Application no: H11-0724-09

Description: Proposed natural swimming pool with filtration area, beach, bunding, parking, vertical axis wind turbine and landscape works

Amendment: Removal of vertical axis wind turbine

**RE: NATURAL SWIMMING POOL, BEACH, BUNDING, PARKING, VERTICAL
AXIS WIND TURBINE AND LANDSCAPE WORKS AT LONG SUTTON
BUTTERFLY AND WILDLIFE PARK, LONG SUTTON -
APPLICATION REF H11/0724/09**

Site Plan 1:500

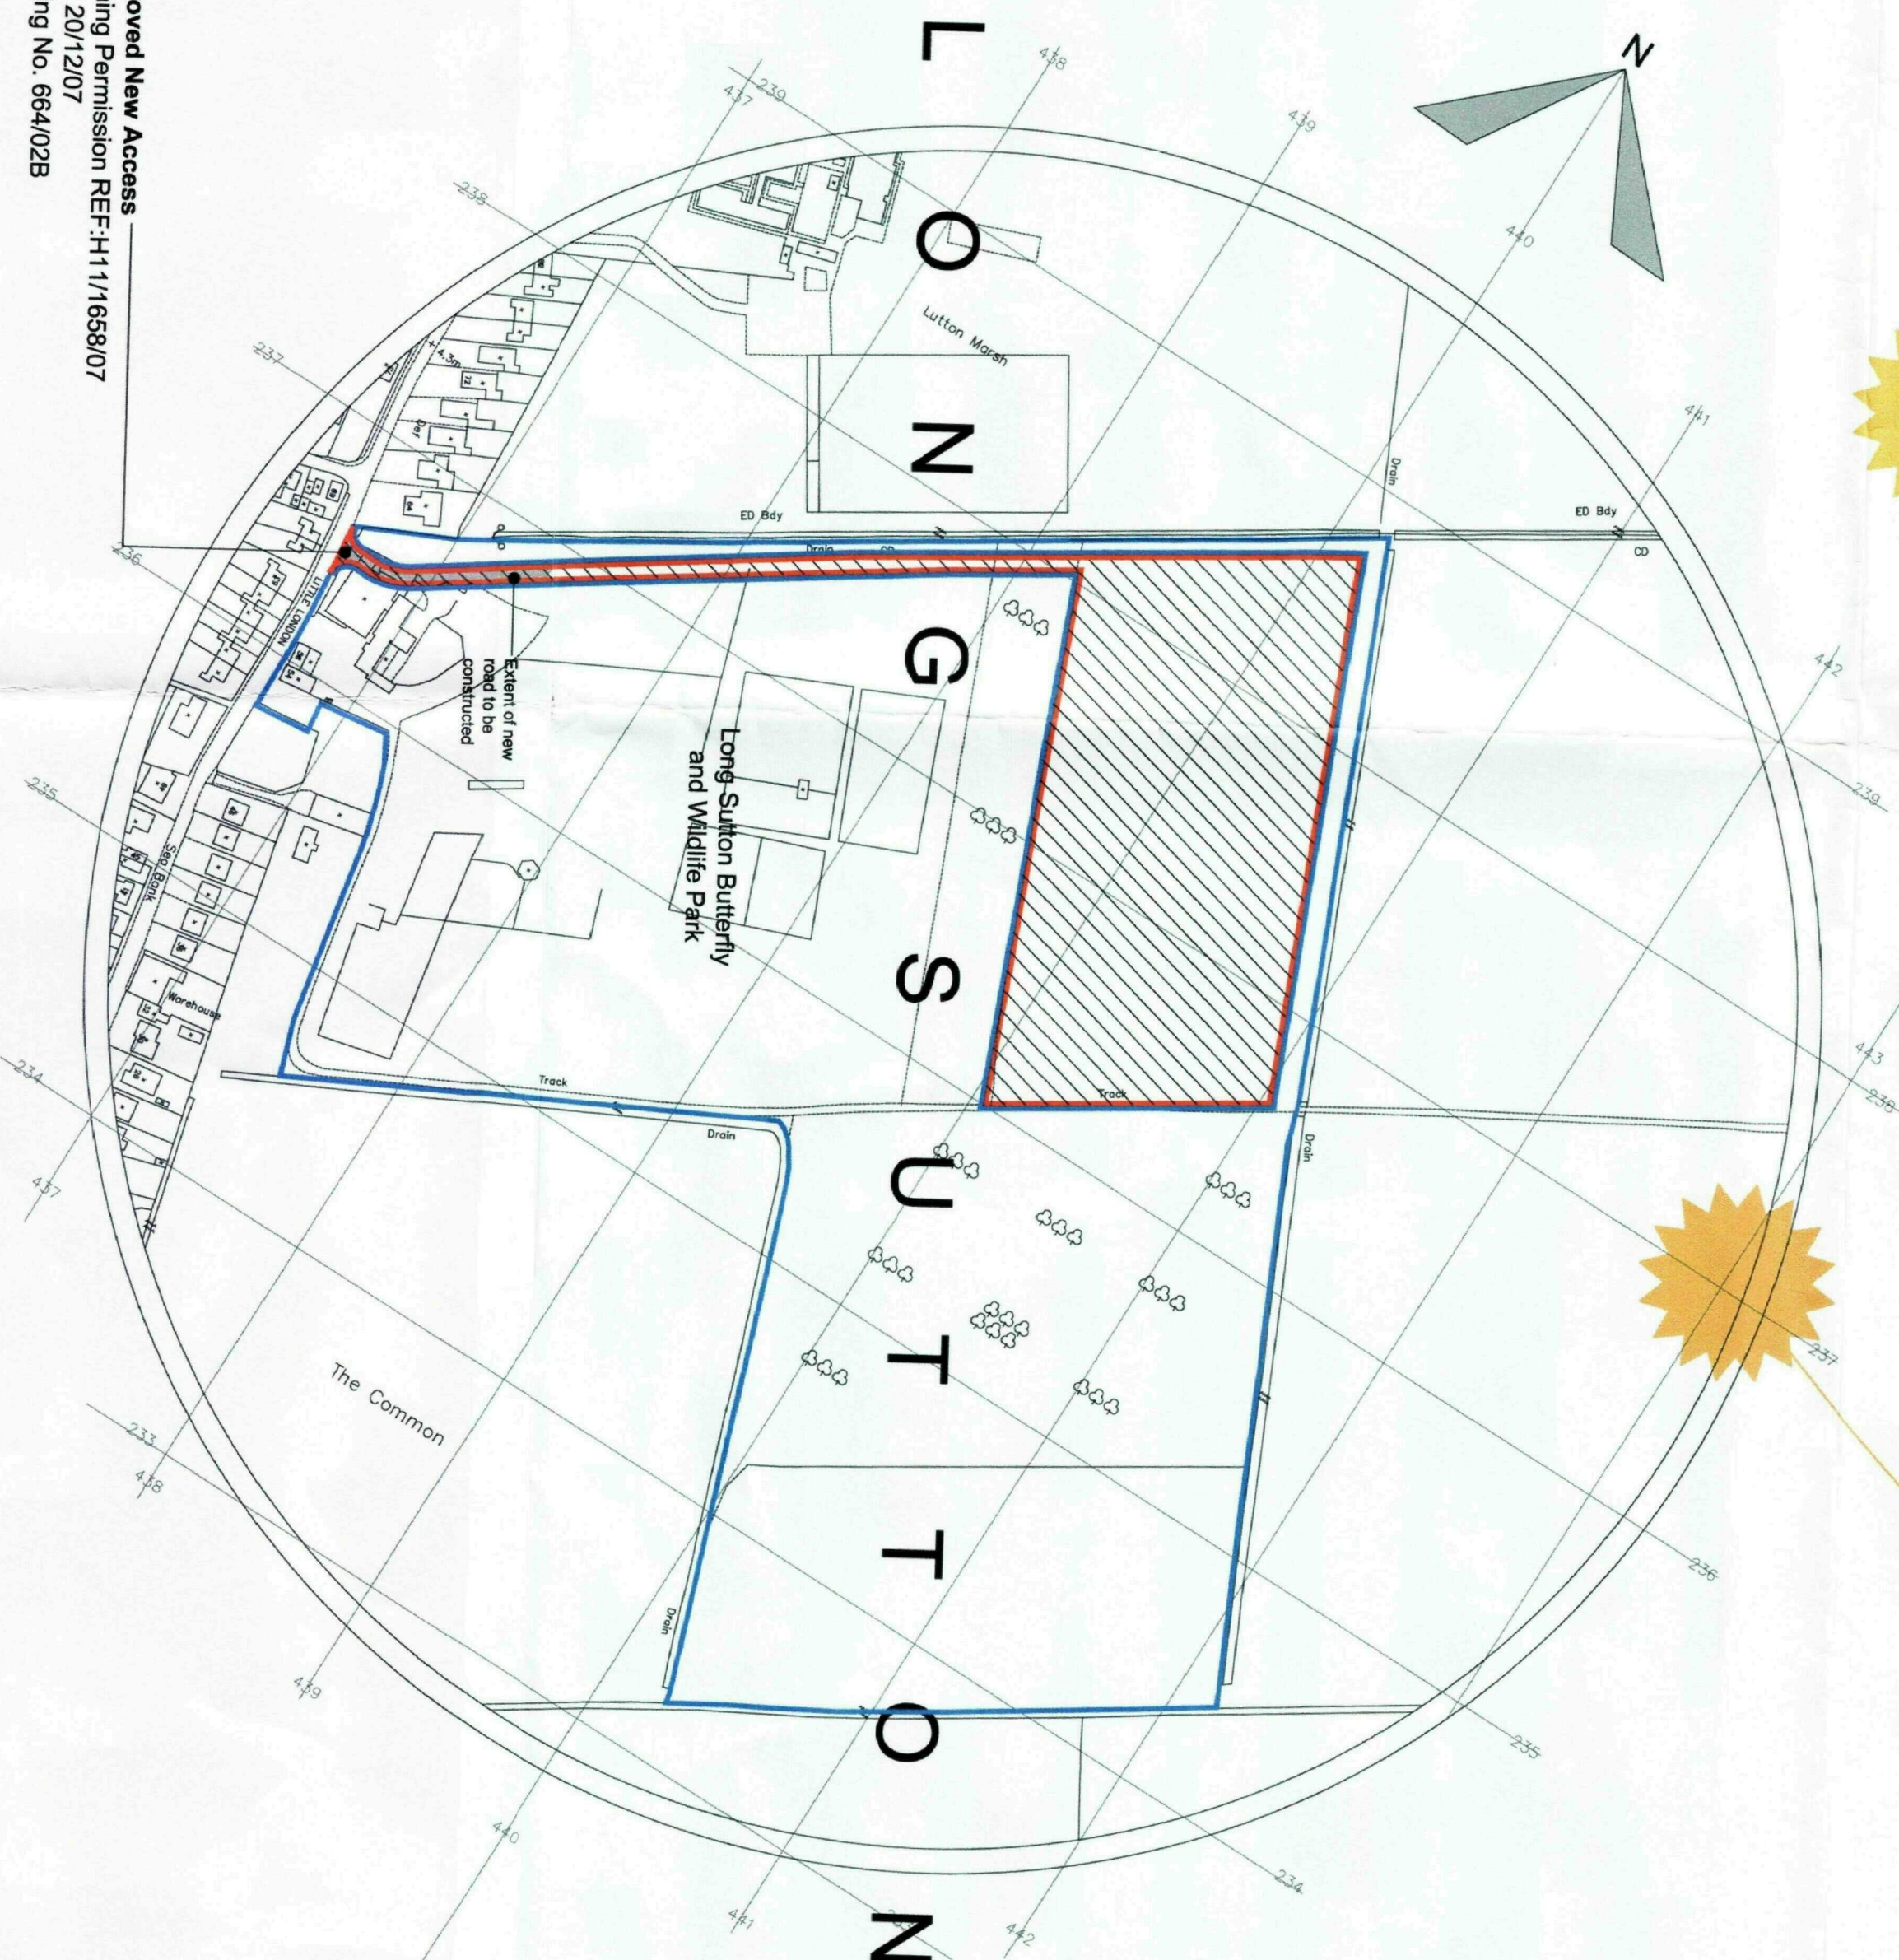
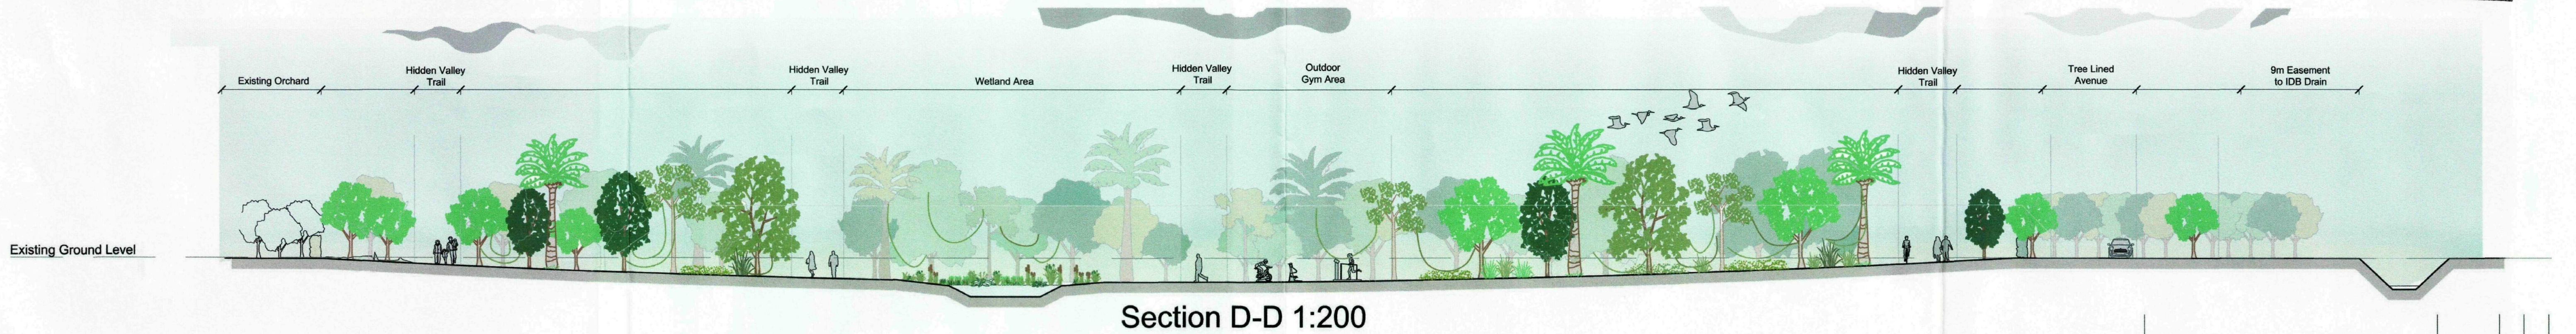
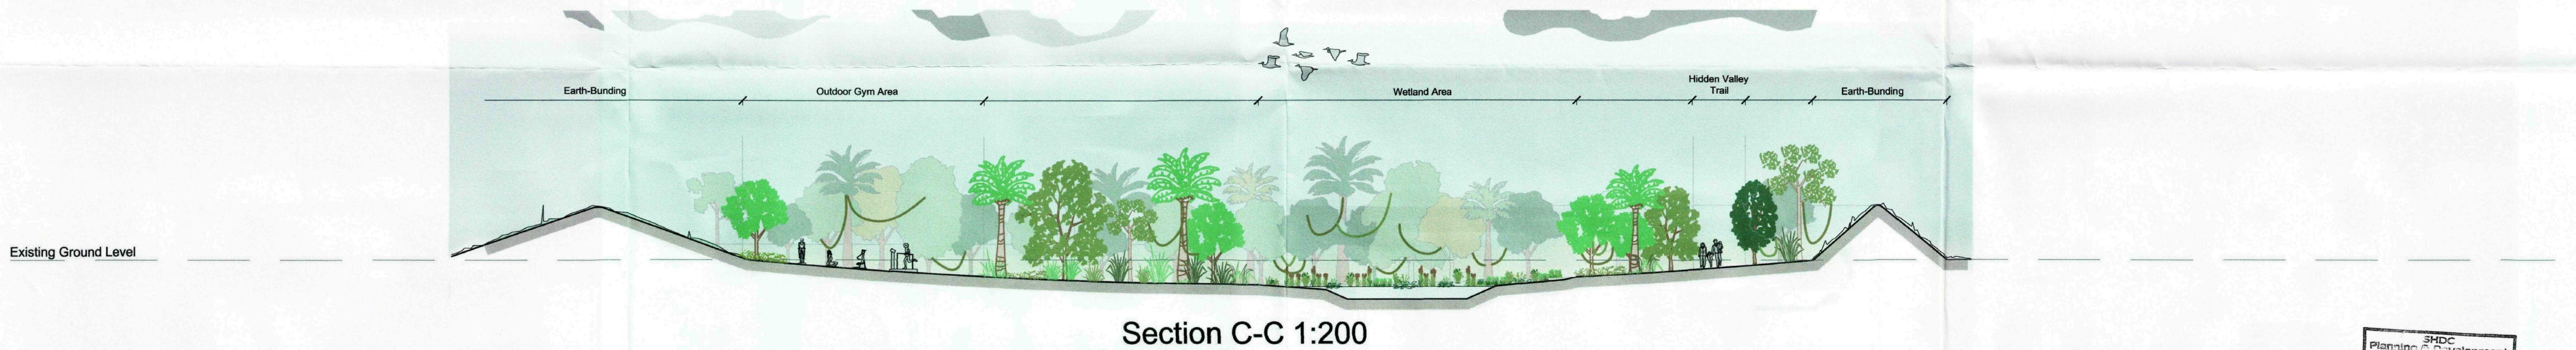
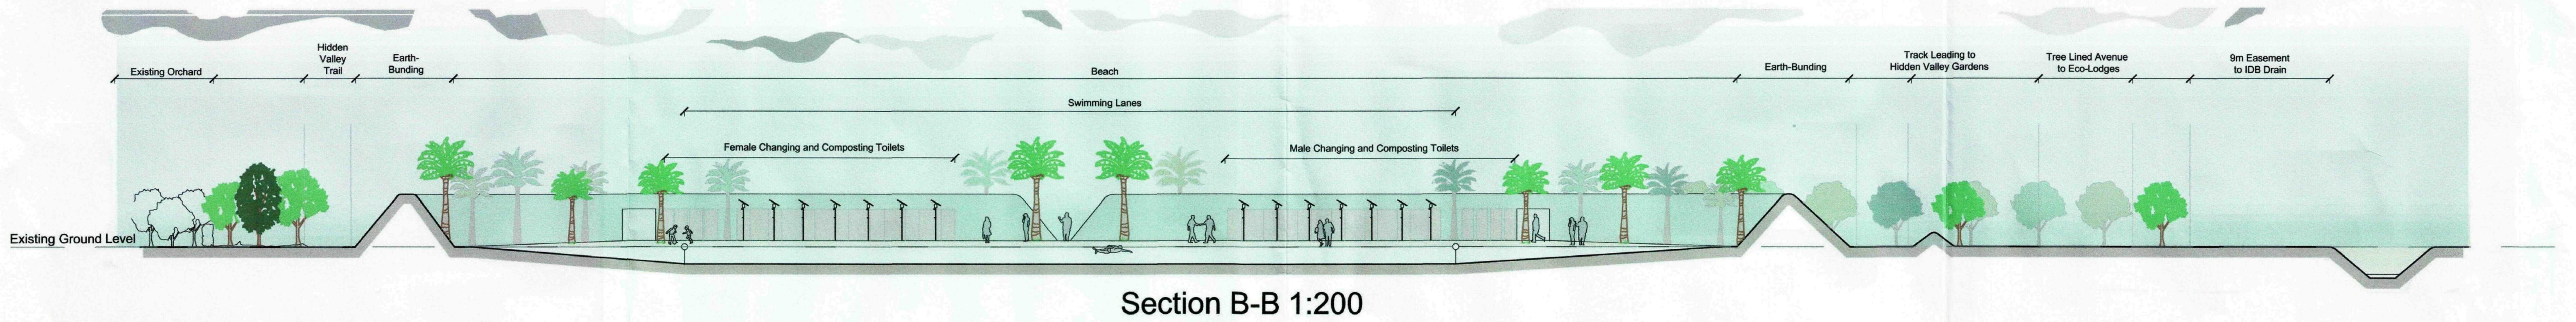
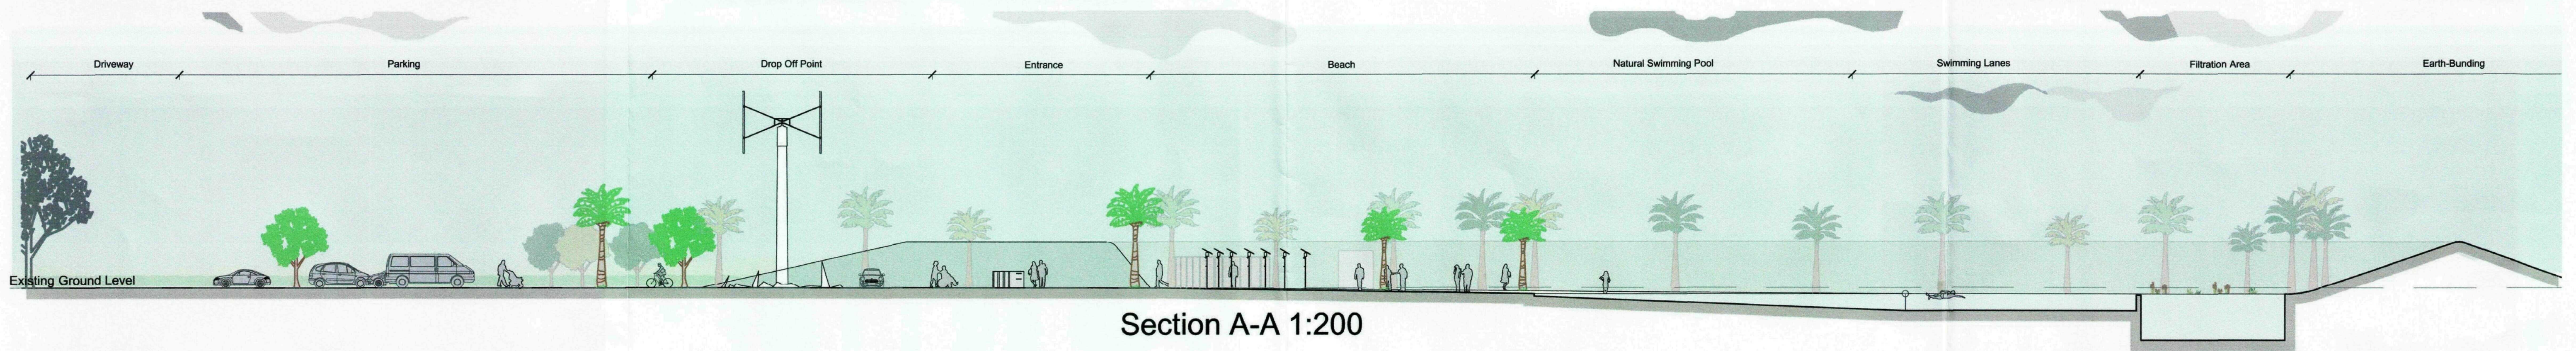
Following your email dated 7th December 2009 and subsequent telephone conversation with Jerry, I can confirm that due to the time constraints we wish to remove the Vertical Axis Wind Turbine from application H11/0724/09. It is our intention to make a future planning application for this element of the proposal, we do however continue to show the vertical axis wind turbine on the drawing for indicative purposes.
